SMP Draft 9/18/19

Sound Measurement Plan REVISED REVISED v9_CzechComments_reduced.pdf
4058K

Appendix 8: LMax dBA Comparison

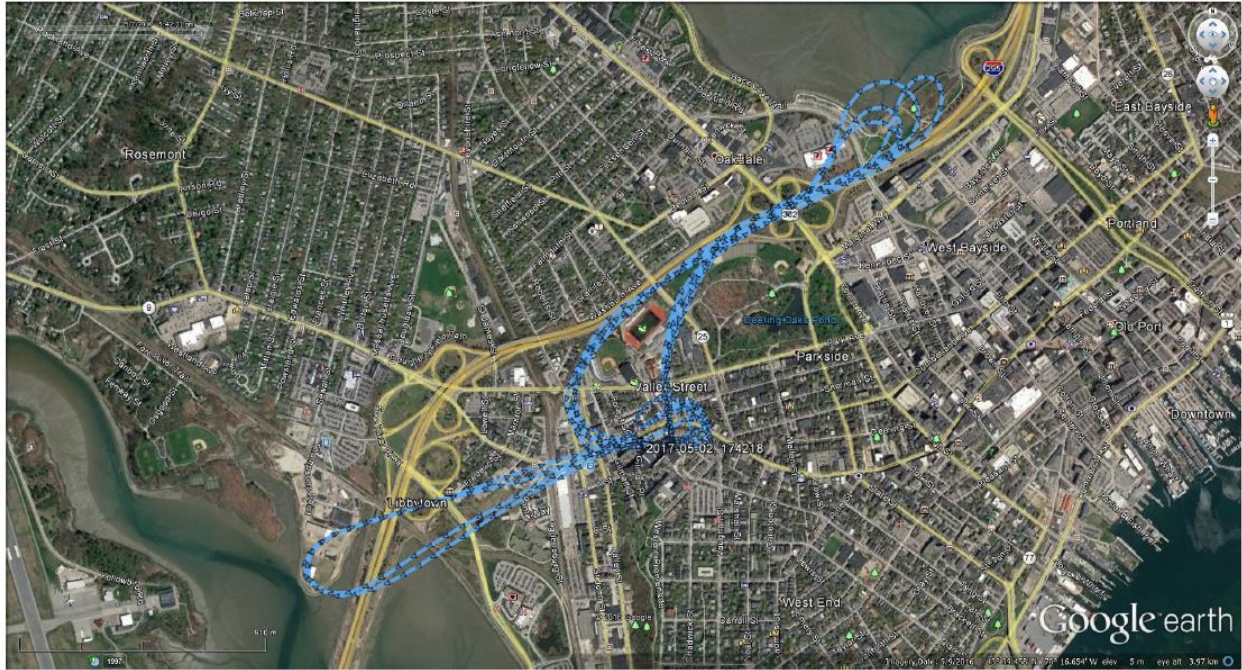
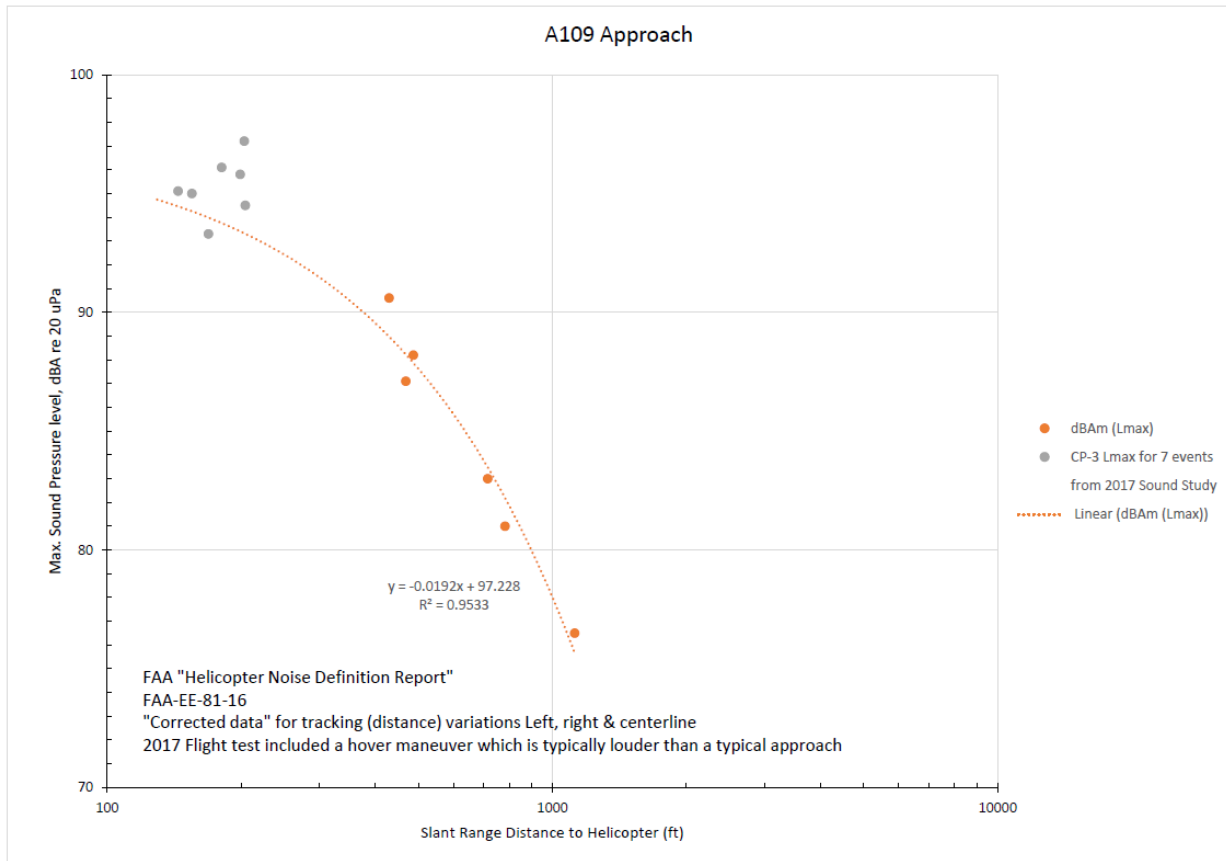
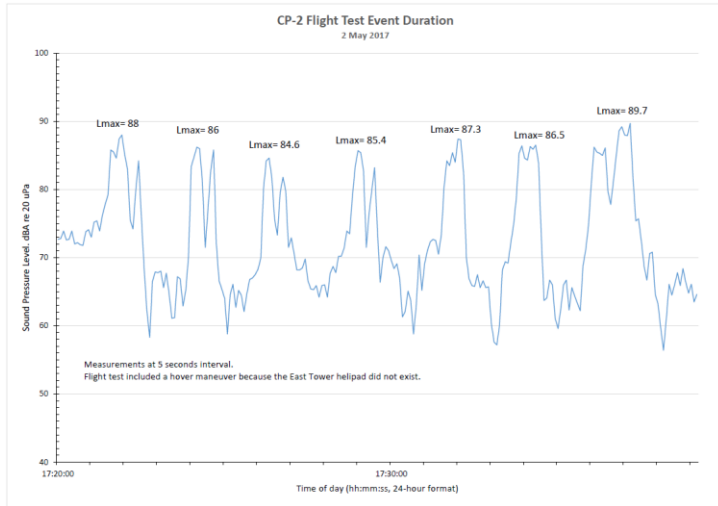
One comment not in the scanned mark-up is regarding section 2c. To clarify and document the number of operations considered by this SMP, I suggest a table showing the:

- a) existing annual operations,
- b) operations increase (delta) due to growth (from increased demand),
- c) reduction (decrease delta) due to addition of 2nd helipad and
- d) total net forecast number of annual operations.
